Application No: K/23/25/HH
Site Address: Cloudy Bay Gorse Avenue East Preston BN16 1SF
Description of works: Extensions to the ground, first and second floors. Removal of existing roof and replacement with a flat roof. Changes to existing fenestration. New front and rear boundaries. Renovation and extension of existing garage. Installation of an air source heat pump and air conditioning units.

Cloudy Bay, Gorse Avenue, Planning Ref K/23/25HH

I am writing to object to the proposed extension of Cloudy Bay on the following grounds;

Drawing Name:
Proposed First Floor Plan

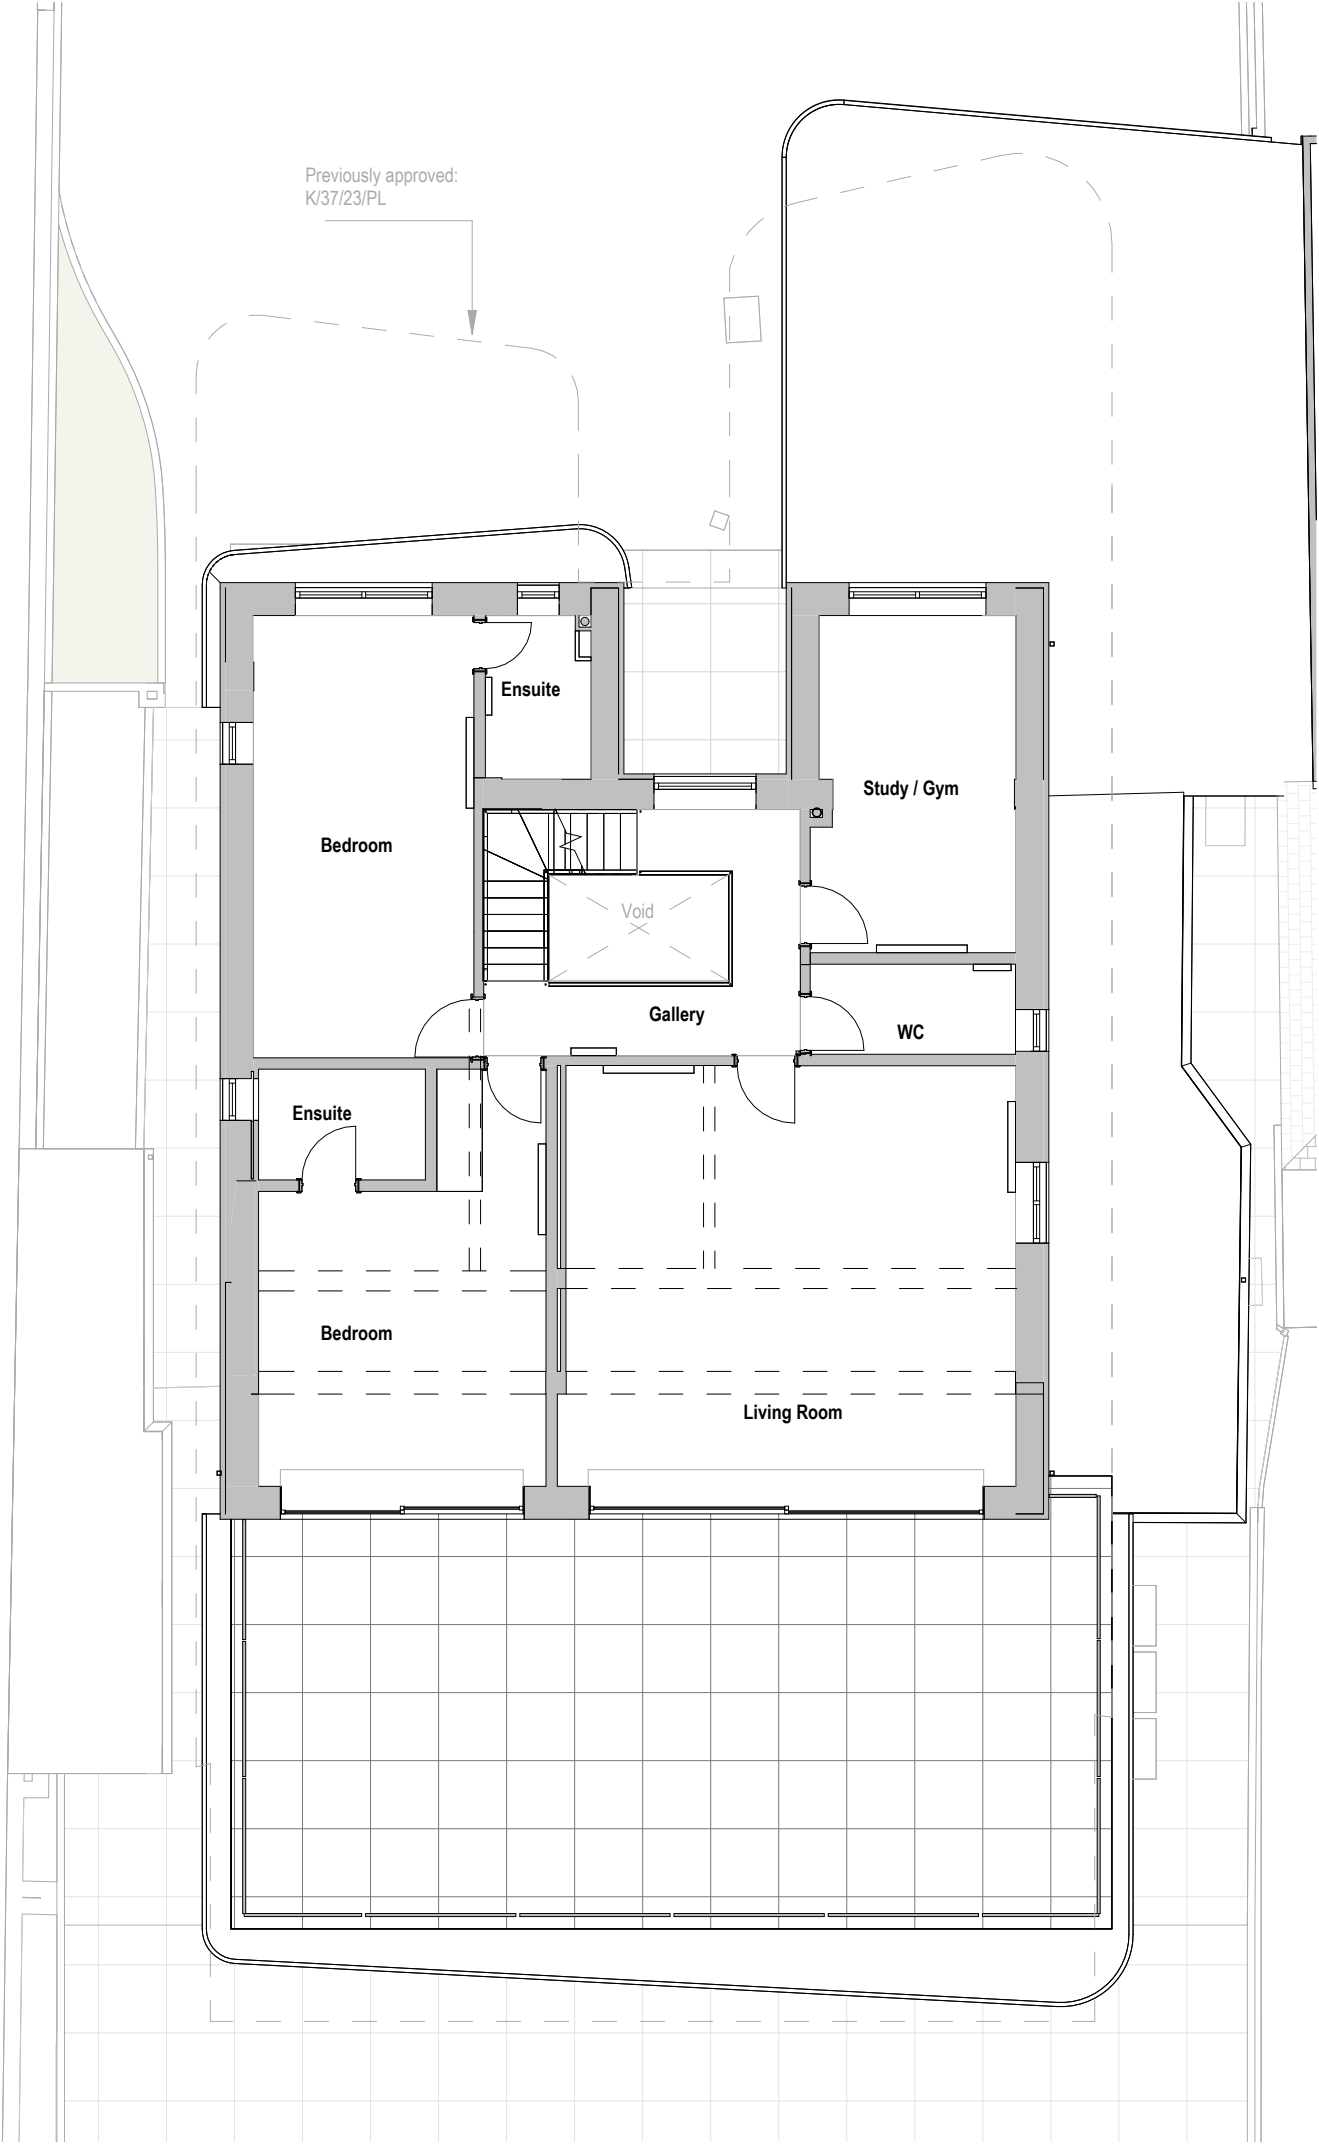
- Siting of proposed development: The proposal is located considerably further south of neighbouring properties Little Deerswood and Sandy Lodge. The proposal will have a detrimental effect on the light and aspect of Little Deerswood. This will be most evident from the first floor bedroom window, pictured below, which will suffer a considerable loss of light. The present room is our son's bedroom. If the plans were to be granted permission, a 'tunnel view' light of the sea will be created due to the first and second floor extension and balcony screening which is proposed. The loss of light will be substantial and highly detrimental.

- Overlooking and loss of amenity. The proposals clearly illustrate the loss of amenity on Littlewood Deerswood main lounge windows by the use of the "45 degree rule". Furthermore the extensive balconies although screened will have overlook our terrace and garden both in perception and in reality.

**Proposed Site Plan**

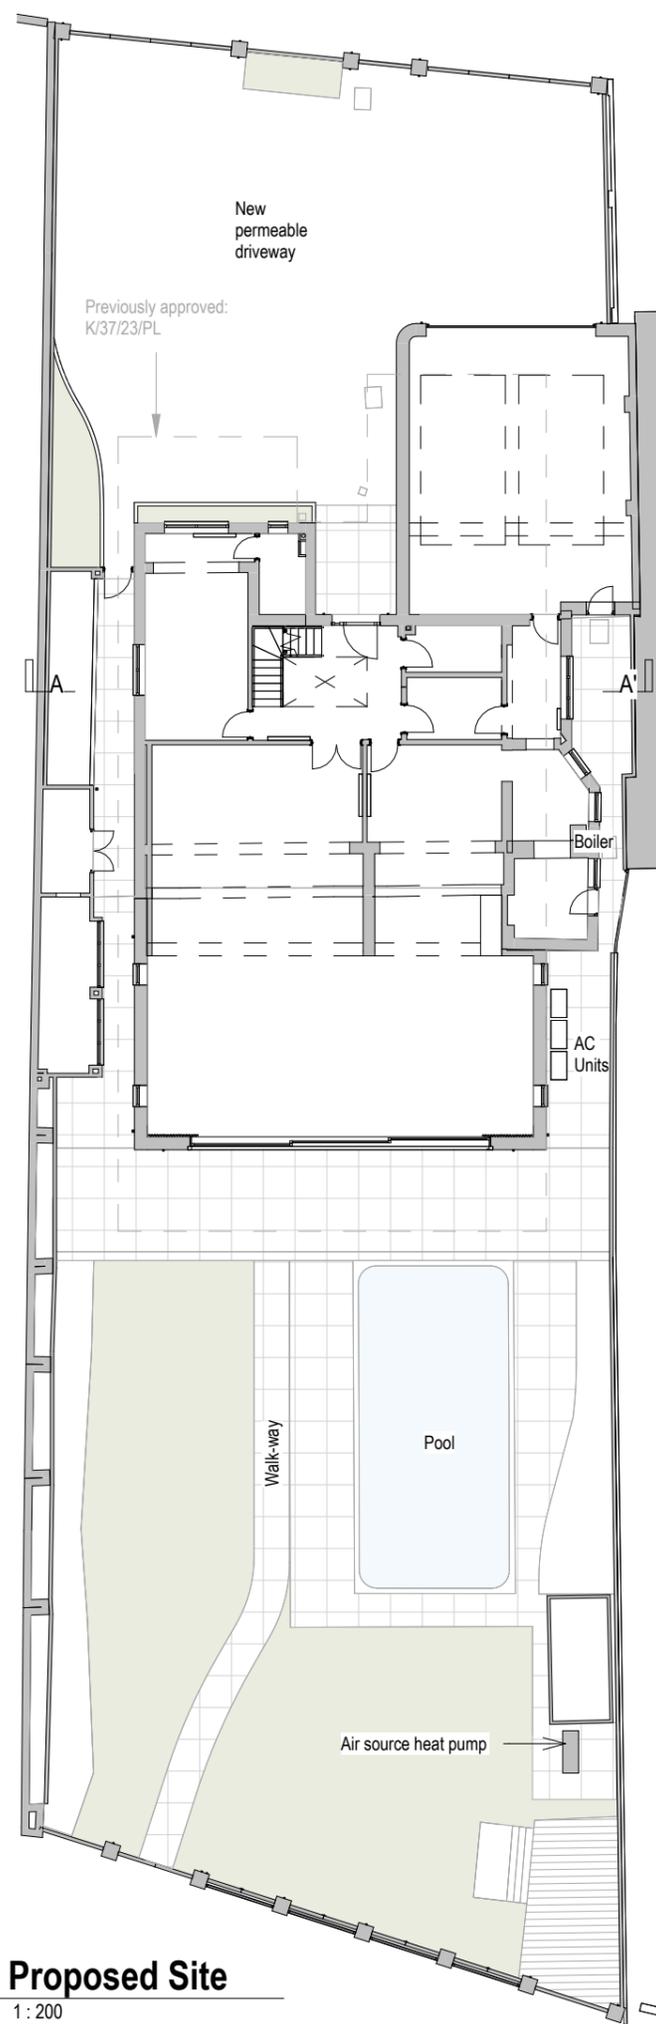
- Overbearing nature and unneighbourly impact: The Cloudy Bay plot is considerably narrower than adjacent plots and the increased height and blank nature of the east elevation will have a significant and unacceptably overbearing and overshadowing impact on both neighbours.

In summary the proposed extension due to its height, bulk and location on the plot would be detrimental to the residential amenities of the adjoining property to the east. It is in conflict with Arun Local Plan policies DM1 & DM4 and Policy KPNP 7 of Kingston Neighbourhood Plan. Ultimately, the local plan is in existence to protect the rights to of residents seeking to develop and residents seeking to protect their homes. If the Council's own policies are not enforced on residents' behalf, it calls into question why we have a plan at all and overall confidence in the Council to act to protect us, the residents. I look forward to a recommendation that this permission be turned down.
